Dear Sirs
Planning Application 2022/62/91139/E
Oddfellows Street Scholes
FAO Mr R A Gilbert

As a householder on Oddfellows Street I write with regards to the amended plans to the proposed development of land off Oddfellows Street Scholes and would like answers to the following questions:

Drawing Title	Site Plan		
Job-Dwg No	OS 100 - 02	Rev	H

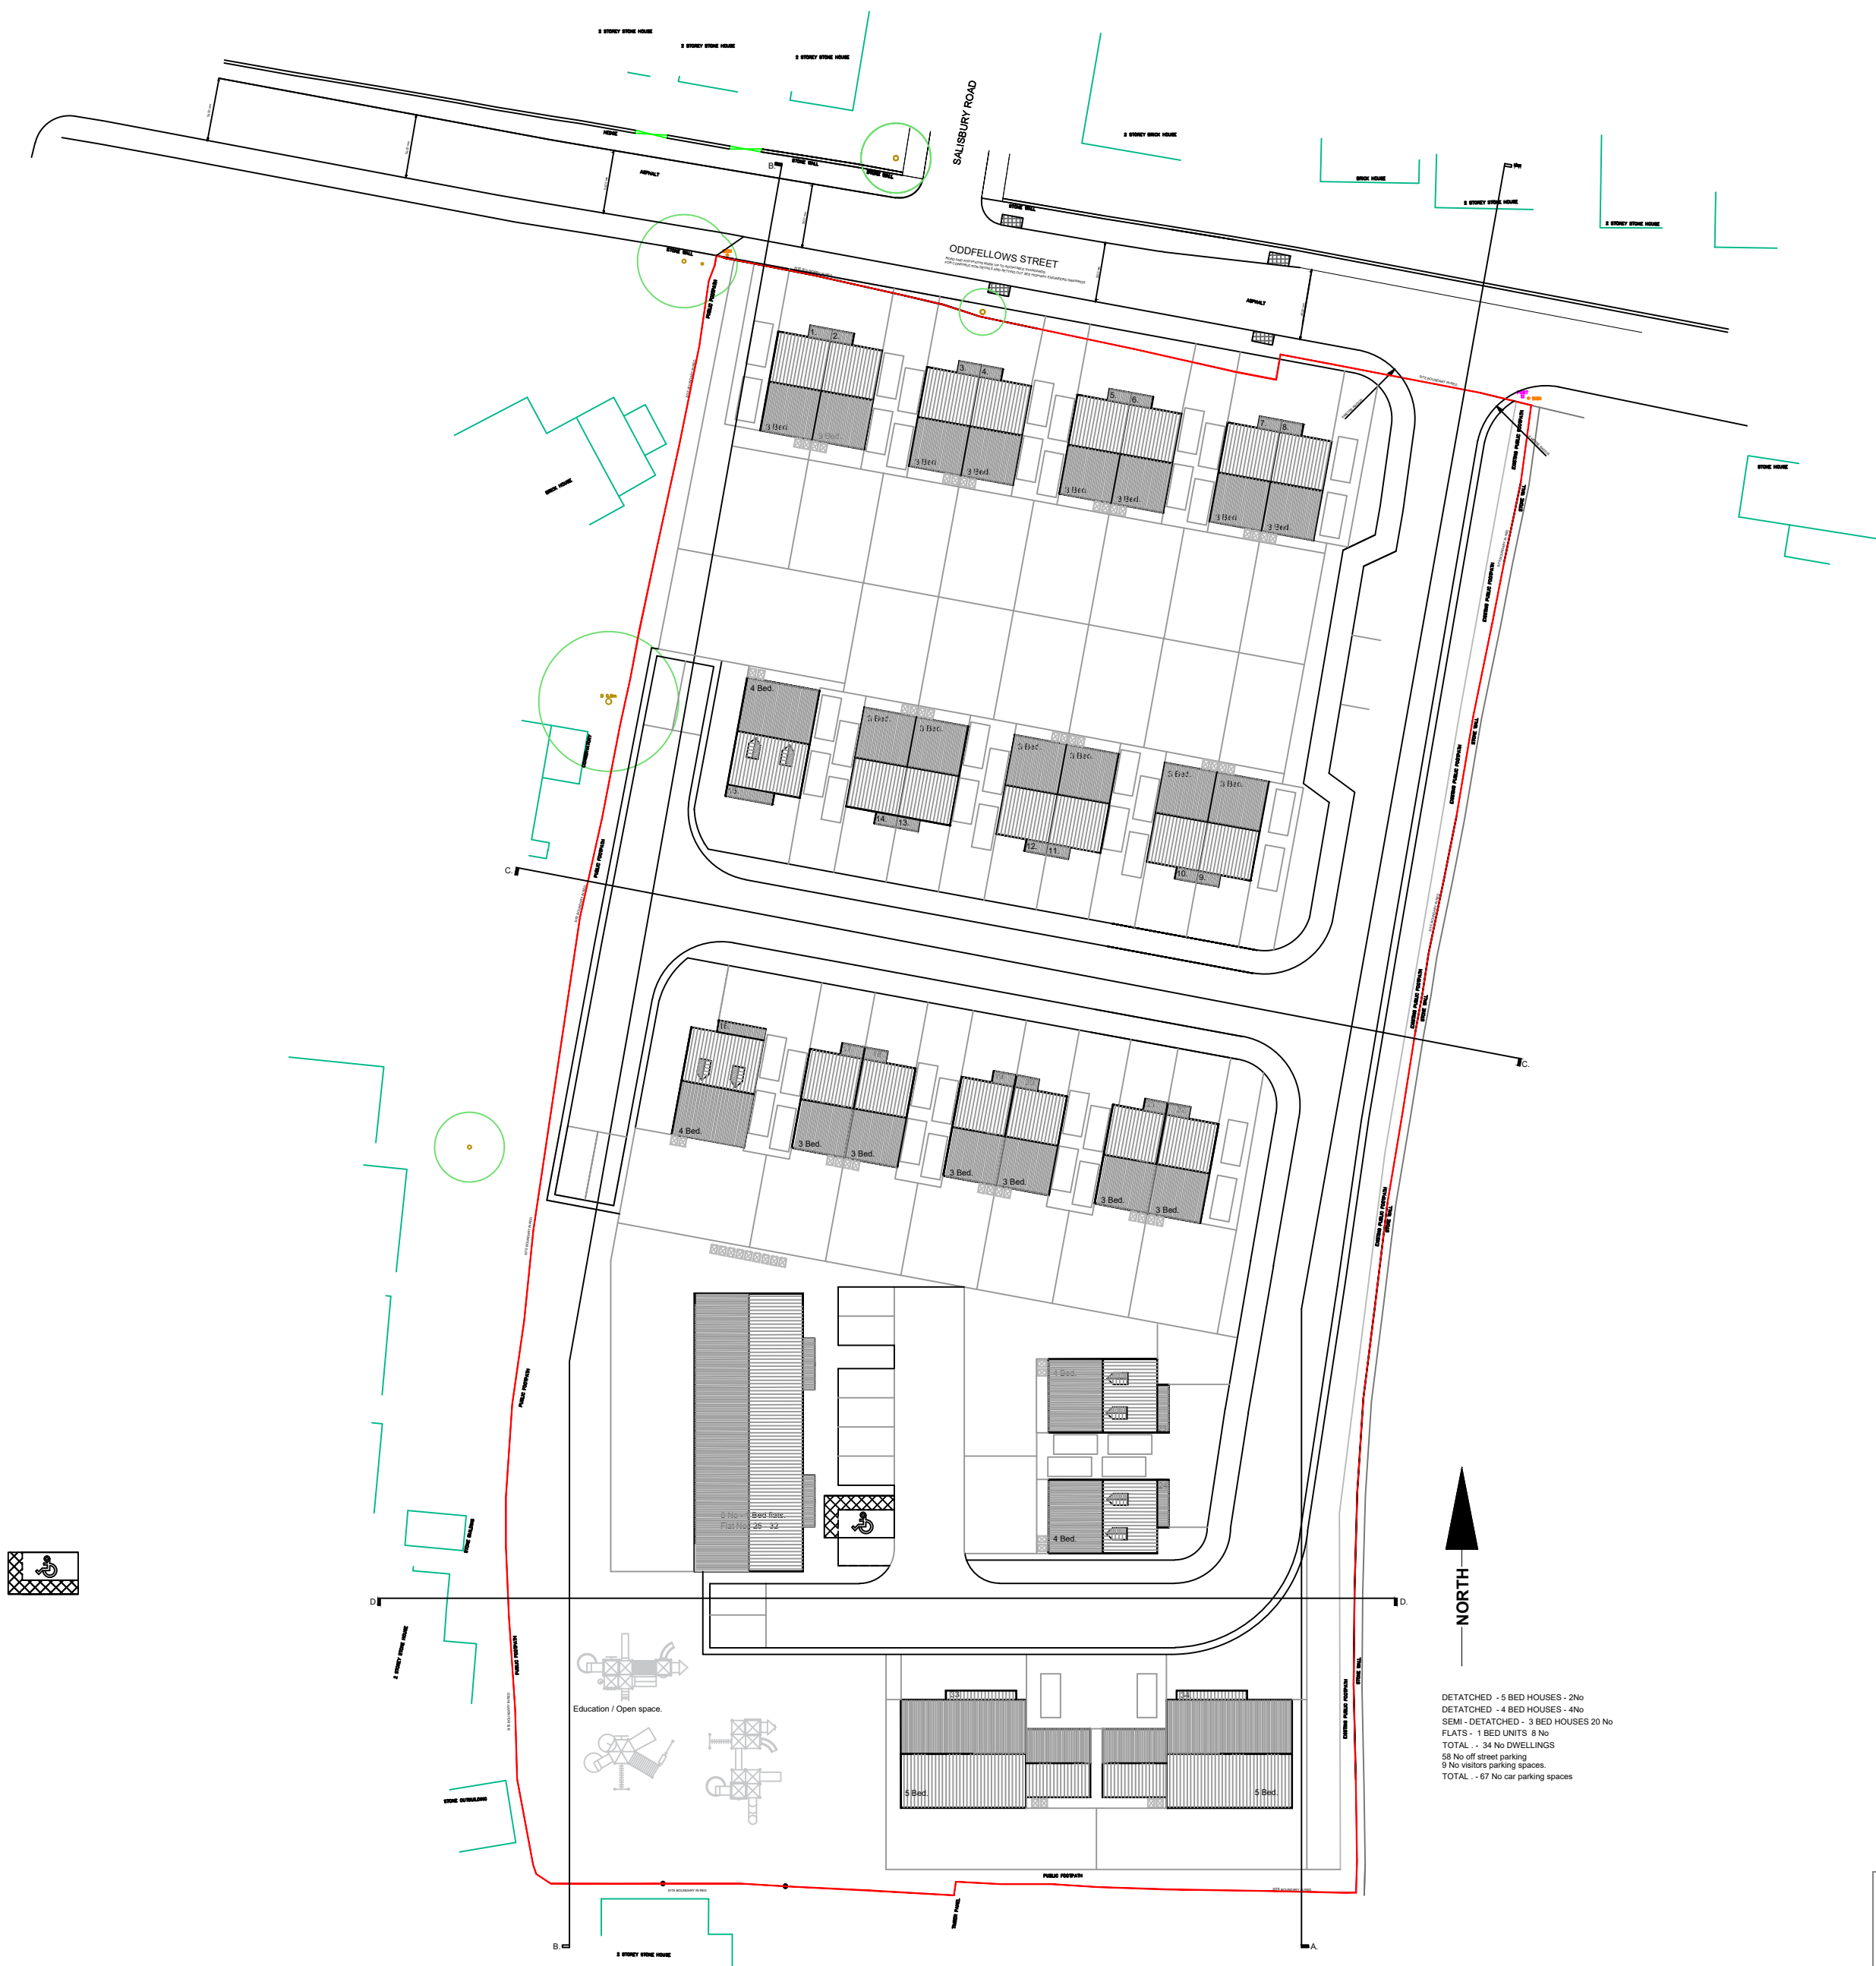
- 3) The residents of Oddfellows Street all use "on street parking" on their part of the street. The revised plans show 2 entrances to the proposed site which are directly opposite existing properties. With everybody parking their cars on the street this effectively

reduces the road to approximately half its width. How are emergency services, HGV's, refuse lorries and building contractors going to negotiate such a narrow entrance?
